**Case Officer:** Linda Griffiths

**Recommendation:** Approve

**Proposal:** Discharge of conditions 8 (Levels), 11 (Drainage Phasing), 19 (Protection of PROW), 20 (Details of Footpath, bridleways & Tracks relevant to RM), 22 (Spoil Management), 23 (Soil Management), 25 (Street Lighting), 32 (Trees,) 42 (Bridleway Protection), 48 (Access during Construction) & 49b (Site Specific CMP) of 14/01932/OUT relating to the construction of the main spine road.

drawing title
Annex EDP 1: Tree Constraints Plan Overview

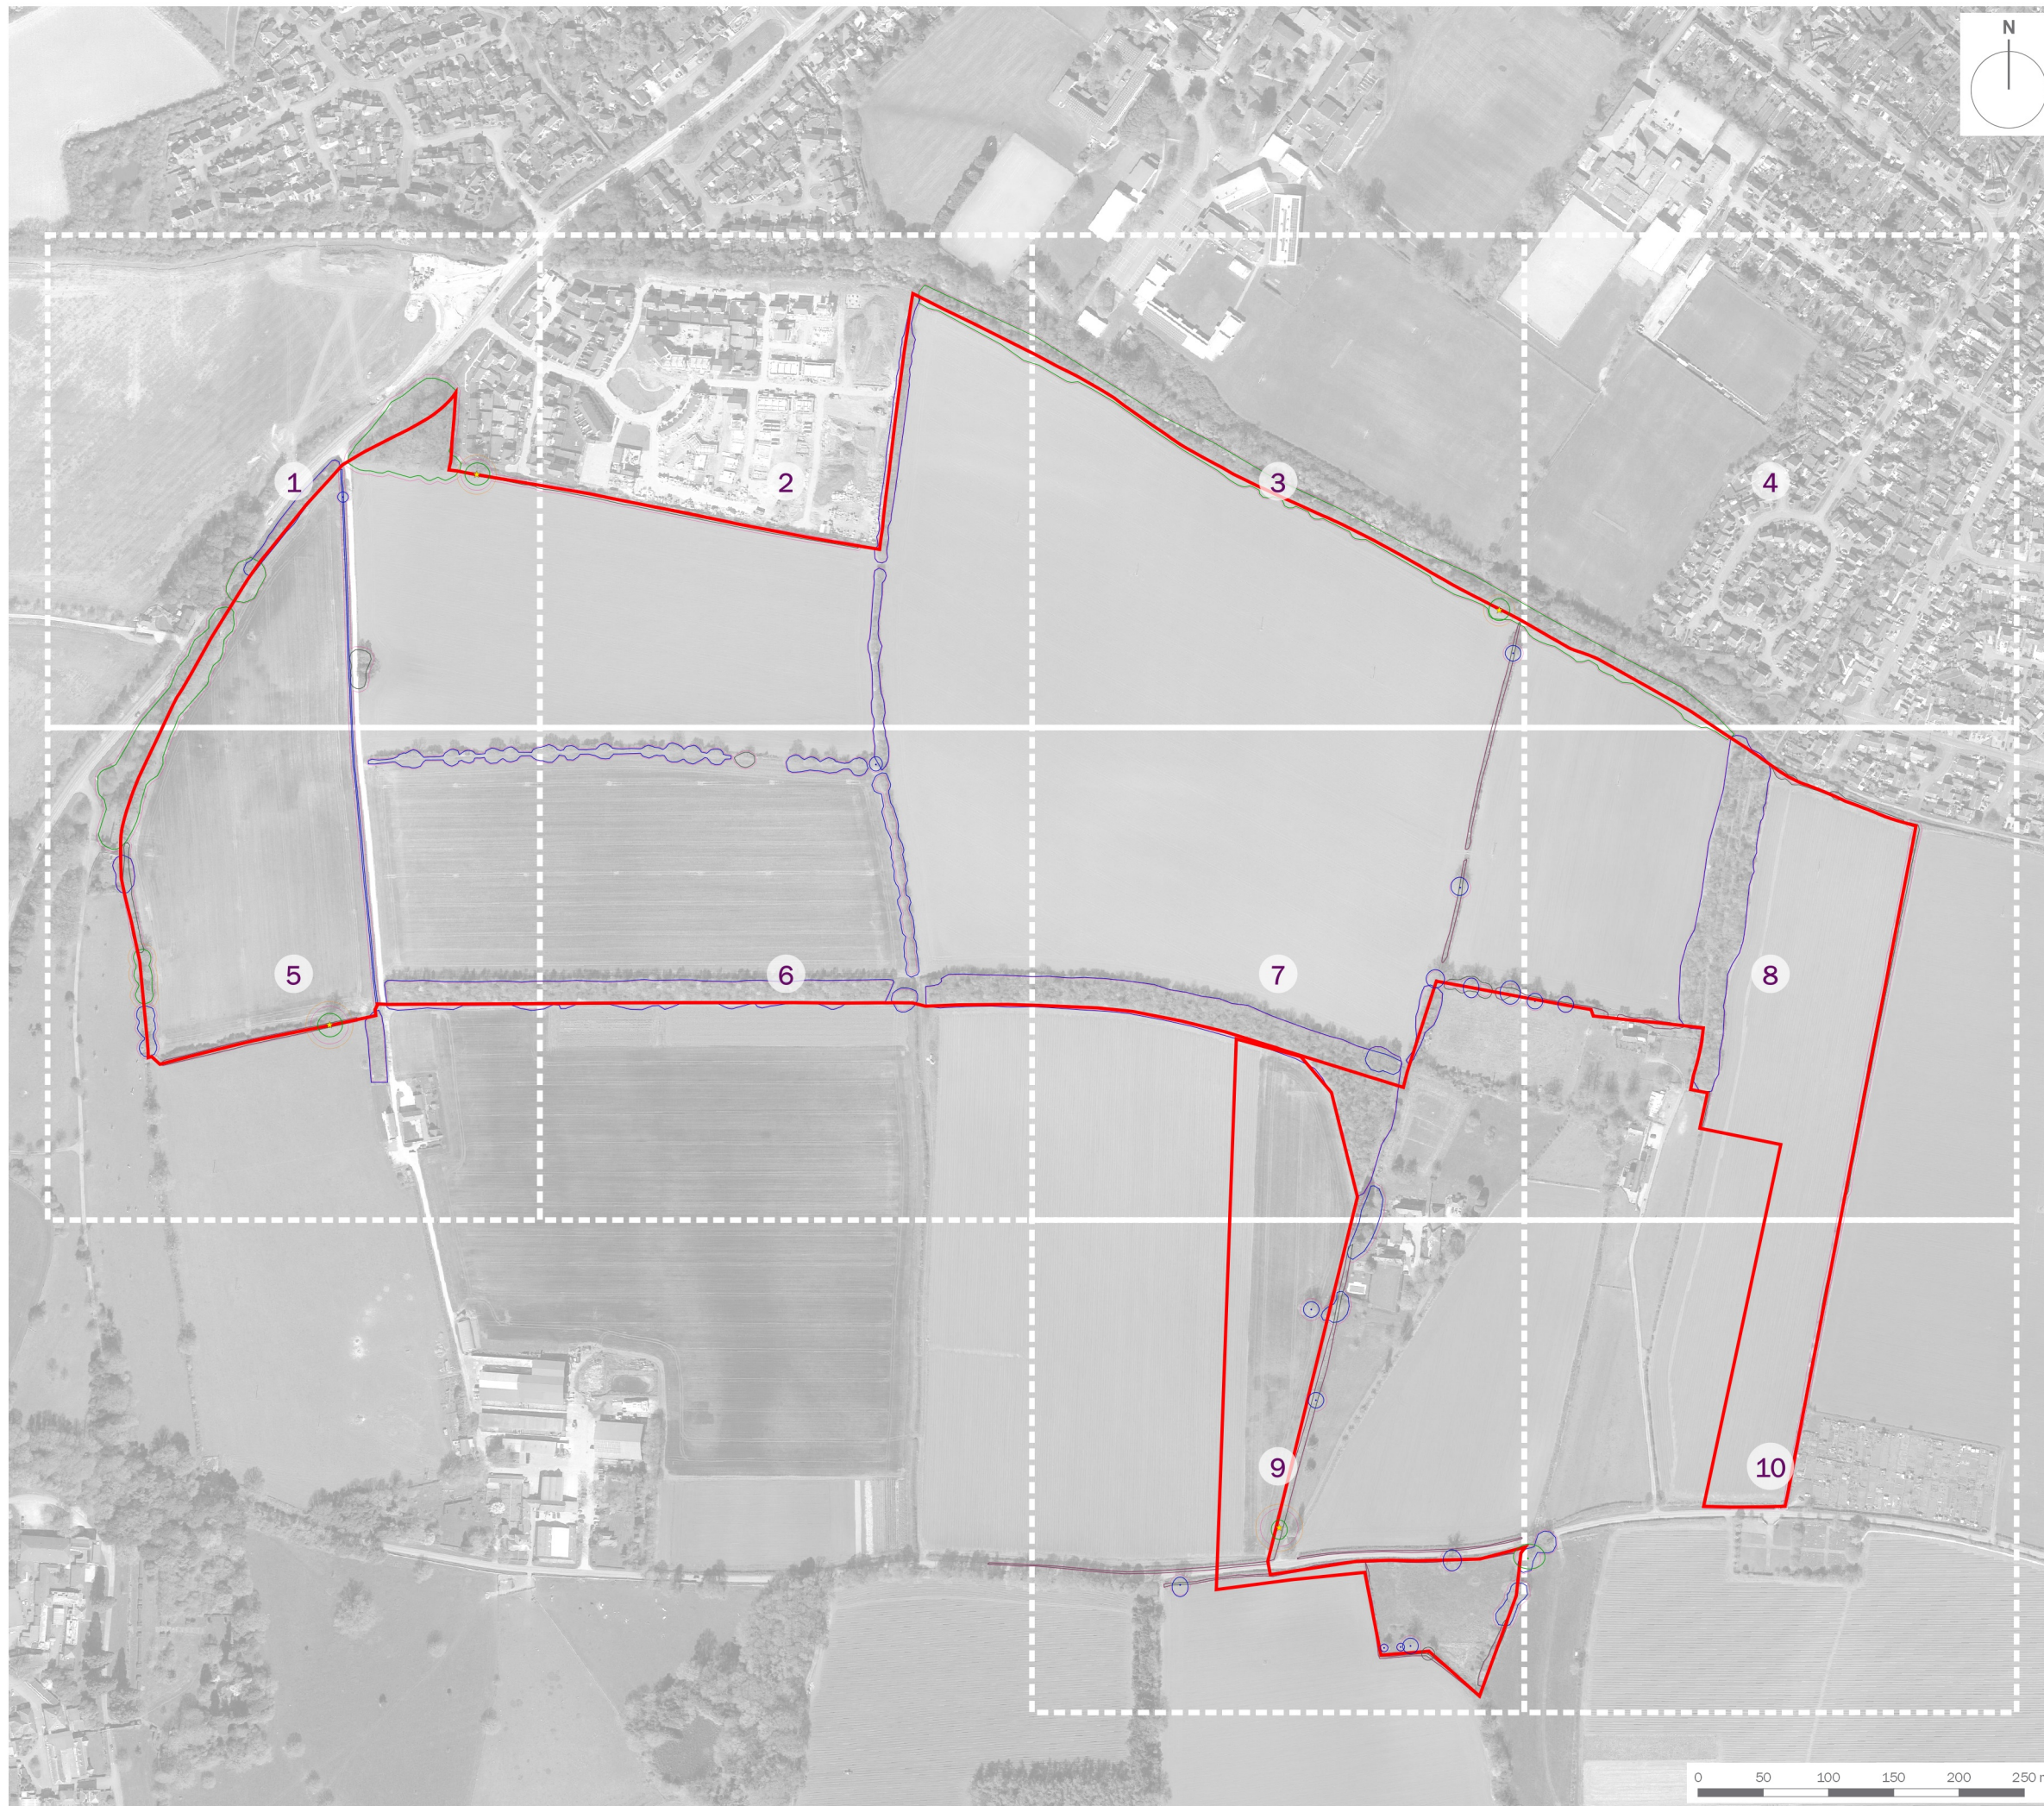
- 4.3. Arboricultural Officer – main concern relates to the removal of tree groups 41, 42 and 43 which are more effectively a hedgerow of about 400m that have been categorised as B under BS 5837, so should be retained unless there is substantial reason to remove them. The road should have been located to the south of this which is also a bat travel route.

- 5.8. Condition 32 – relates to the protection of trees and hedgerows. The concerns of the arboricultural officer are noted, however, the removal of the length of hedgerow referred to has already been agreed through the outline submission. Therefore, the condition is discharged accordingly.
